From: Brenda Larsen
Sent: Tuesday, June 25, 2013 2:16 PM
To: Jeff Watson
Subject: RE: BL-12-00029 Ellis

Re: Ellis (BL-12-000029)

After conducting a review of the above named project, I have the following comments:

Diagram of Adjustment Request

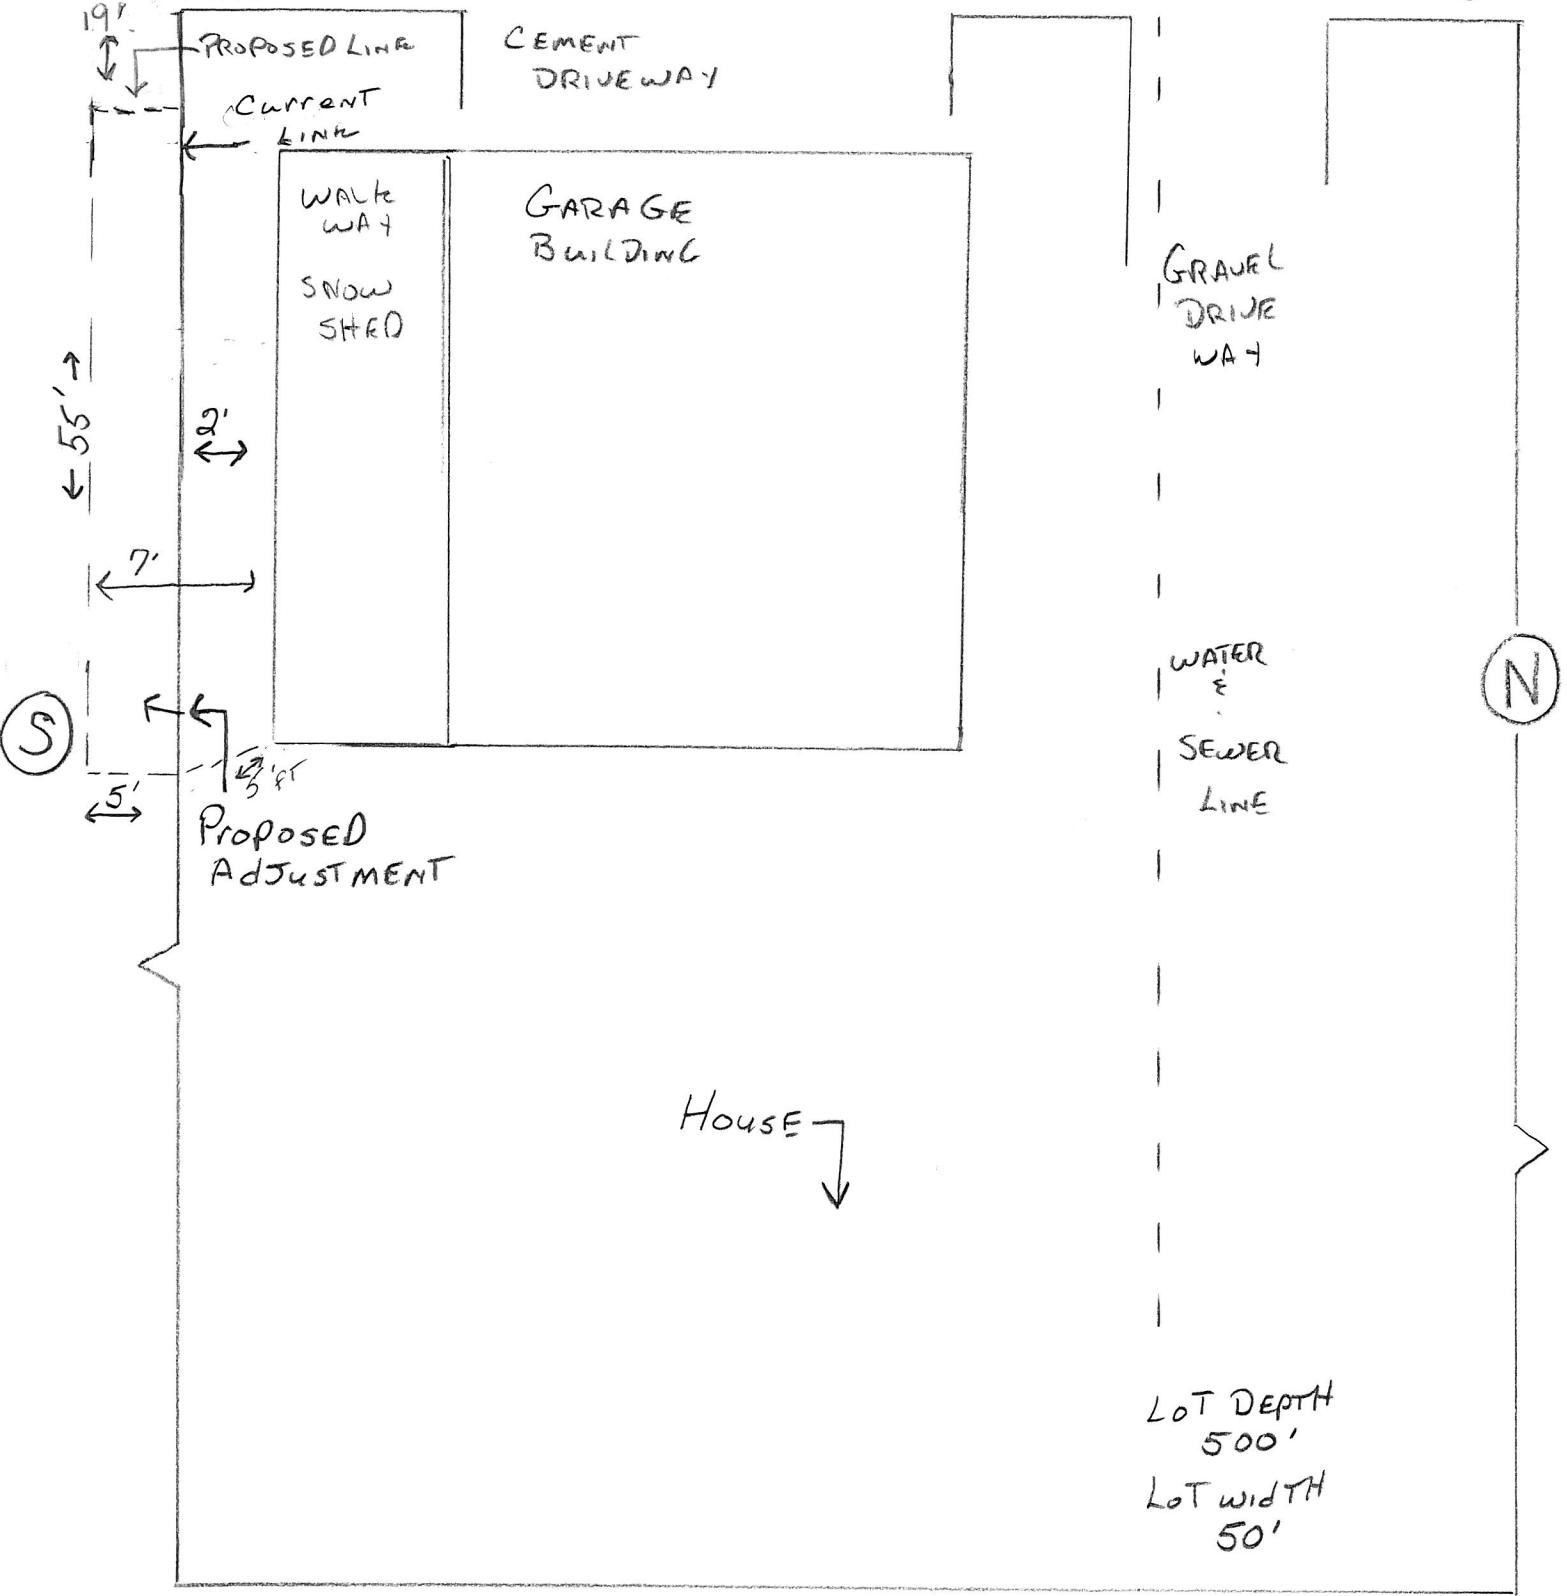
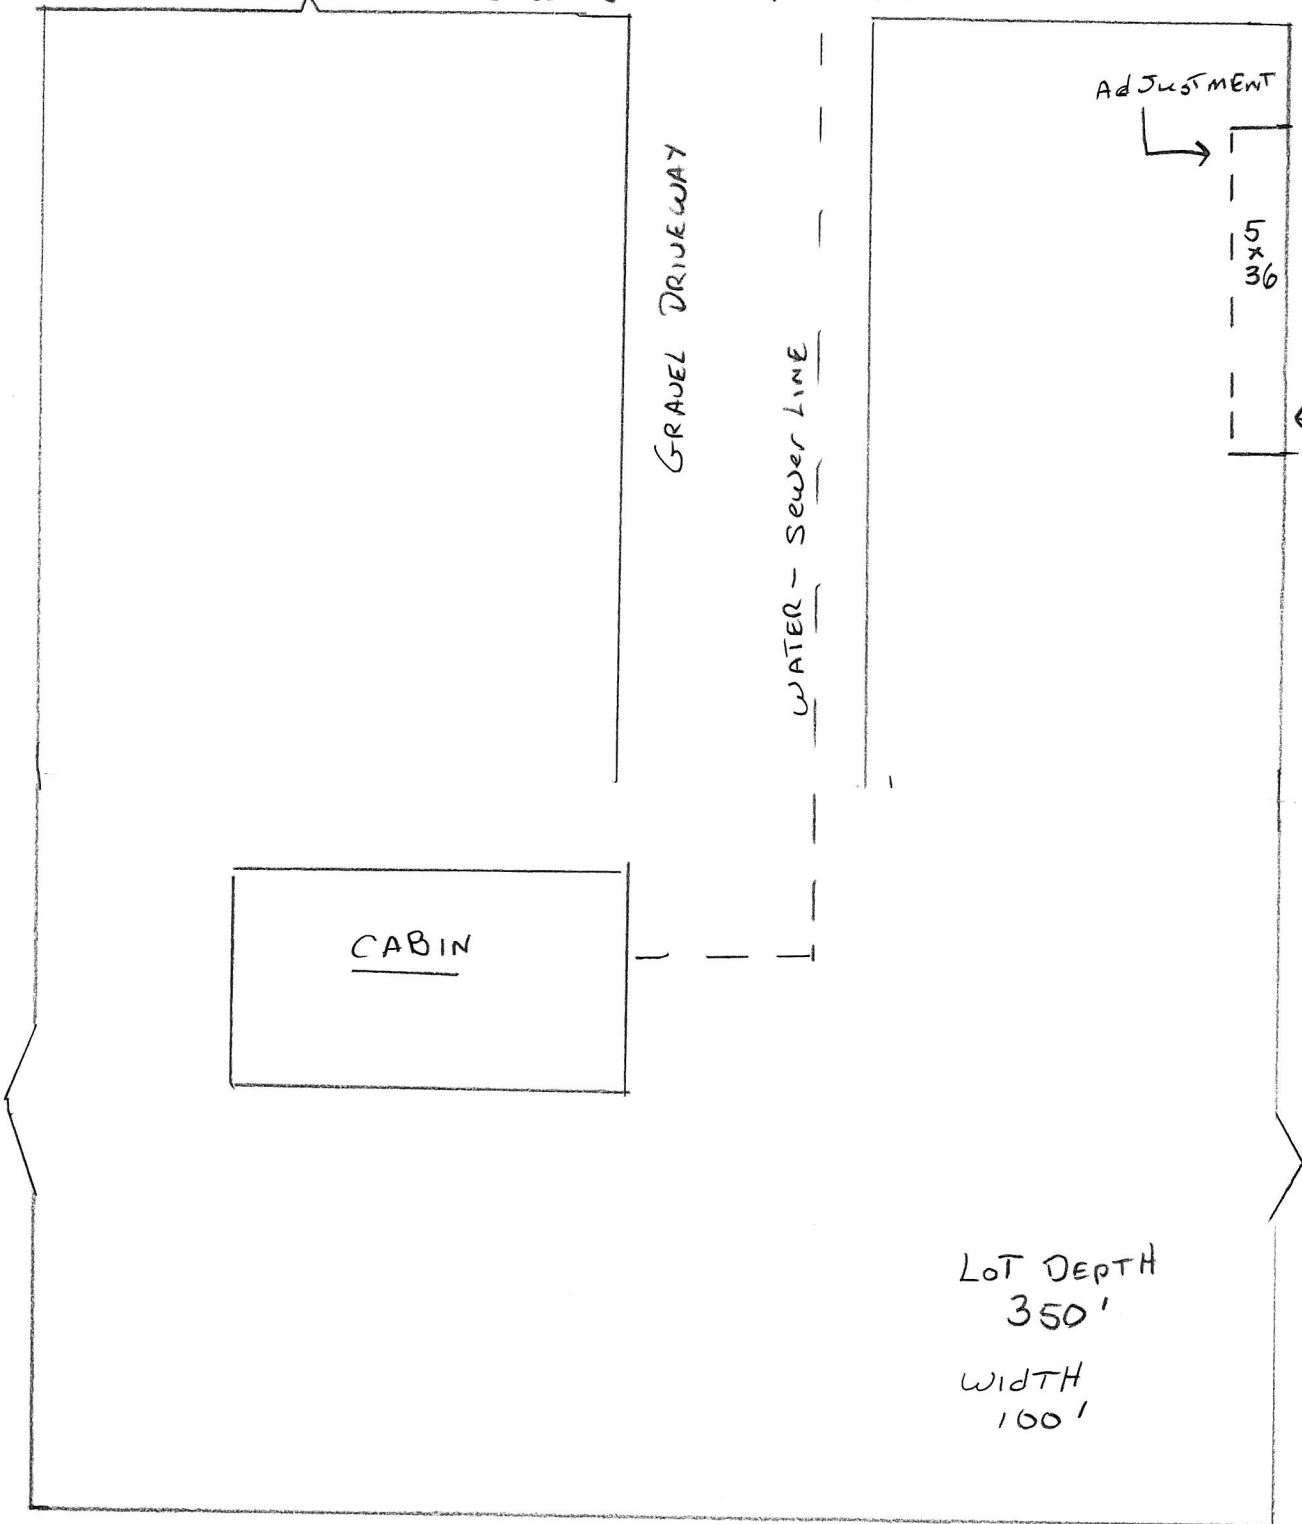
- Ensure that boundary line adjustments do not infringe upon existing structures, to include propane tanks, etc.
- All future development must comply with the International Fire Code.
